Application No: CM/12/25/PL

Site Address: Rigates Climping Street Climping BN17 5RQ

Description of works: Demolition existing buildings and erection of 1 No. self / custom build dwelling and garage with associated landscaping. This application may affect the setting of a listed building, is in CIL zone 5 and is CIL liable as a new dwelling.

Thank you for your internet representation made on 26th May 2025 which has been recorded as an objection with the comments as follows:

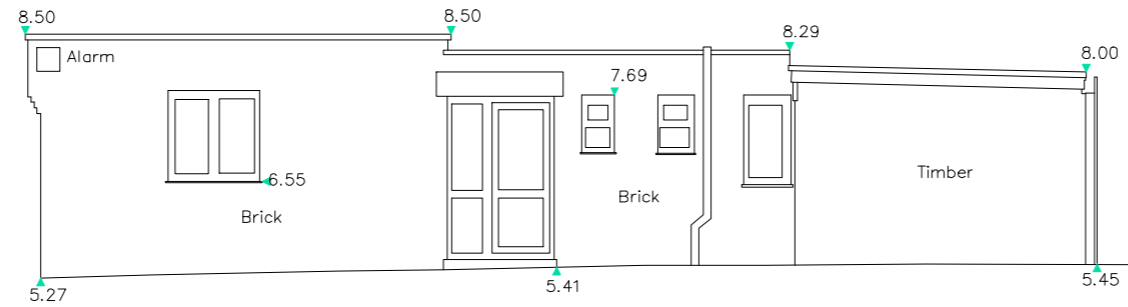
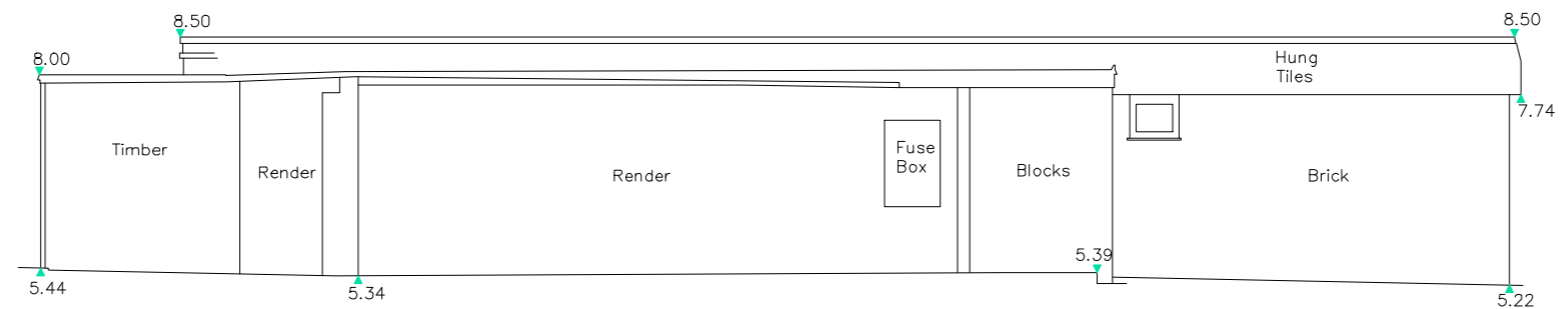
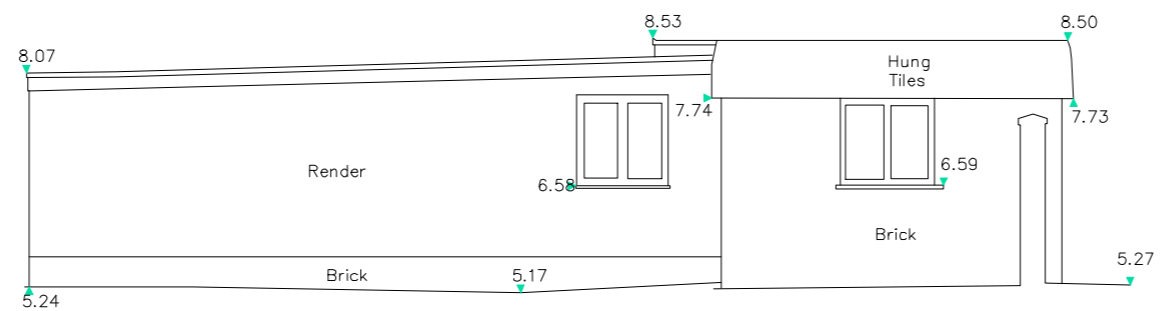
I object to the height of the house that is being proposed located next to my property. The ground level on their side of the fence is higher than mine therefore the house will appear a lot higher than the drawings suggest and will be an imposing structure overlooking my private garden. I know there are trees along the property line, but they won't be in leaf in the autumn/winter/spring months and my privacy will be gone. I suggest a 4 bedroom bungalow/a single storey house which would be more in line with the natural habitat and more in line with the existing building which is being demolished to make room for the new one.

I also object to the balcony which will overlook my property. The building is at such an angle that the balcony will have a greater view of it. Again, there are trees but they won't be in full leaf all year round and my privacy will be gone.
